Rio Grande Credit Union

Administrative Amendment Request

Project #PR- 2020-003561

Transportation Development Comments:

NOTE: ASPHALT ABUTTING THE EXISTING PARKING LOT TO BE AT SAME ELEVATION. SLOPE ALL NEW PAVING AT 2% SLOPE TO THE WEST. INSPECTOR TO VERIFY

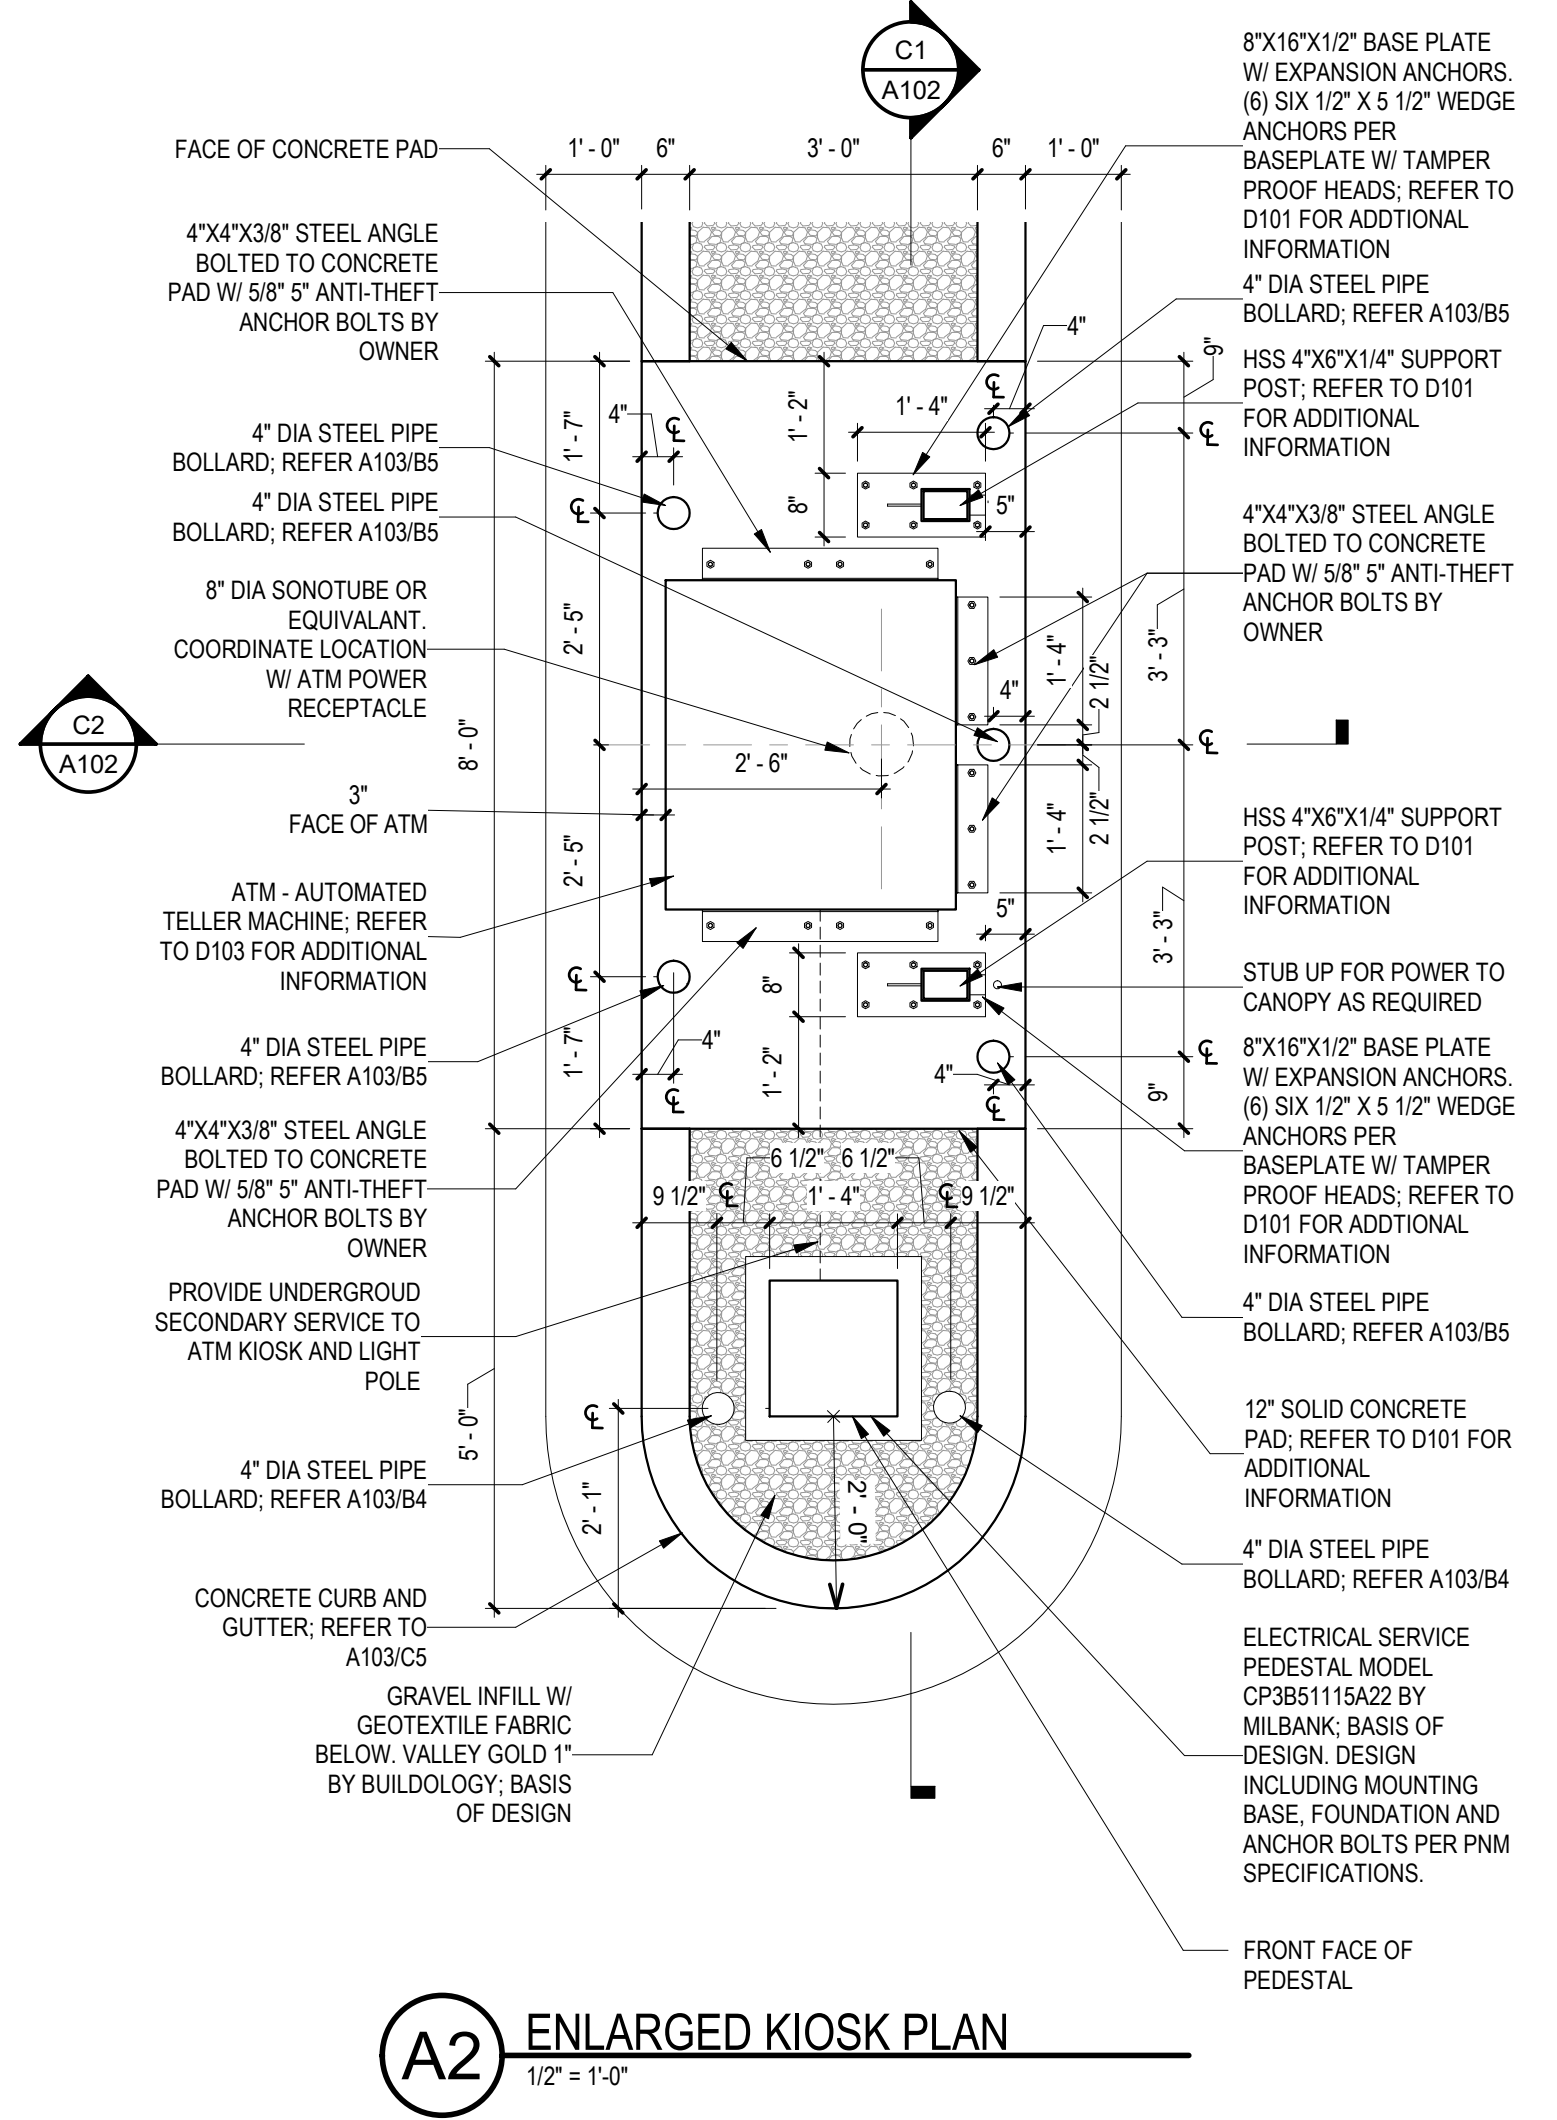
- Q: On Sheet A102, based on dimensions provided, the bollards and adjacent equipment appear to be in conflict with the proposed curb and gutter. Modify dimensioning as needed to eliminate the conflict.

- A: The Construction Documents show the correct design intent. The slab for the ATM and bollards will be placed first and the curb and gutter will be poured after to meet the face of the slab as shown.
- Q: There is a stray keyed note 45 south of the exit of the drive-thru.
 - A:Not Applicable, this item is part of the approved site development plan drawings dated 2008.

A3 TRAFFIC SIGNAGE
1/2" = 1'-0"

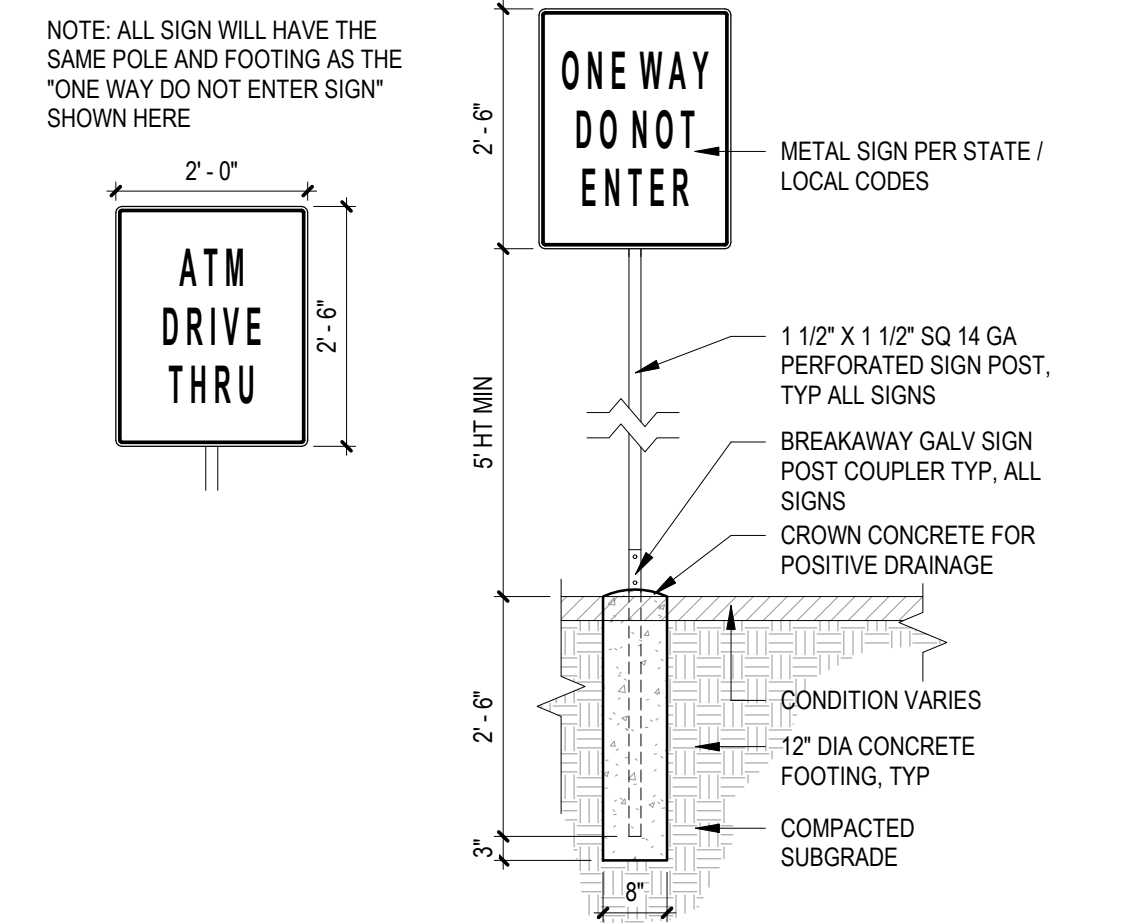
- Q: The detail for the "Do Not Enter" sign on Sheet 2 of 5 does not meet standard. Delete reference to this sign detail, and use the "Do Not Enter" sign per MUTCD sign R5-1. Likewise, on Sheet A103, reference R5-1; "One Way" sign is R6-1 and would be a separate sign oriented parallel to curb for the exit although a "Do Not Enter" sign is sufficient in this case.

- o A: New signage has been updated on Sheet A103 to reference R5-1. We will eliminate the one way sign and utilize the "Do Not Enter" sign as recommended.
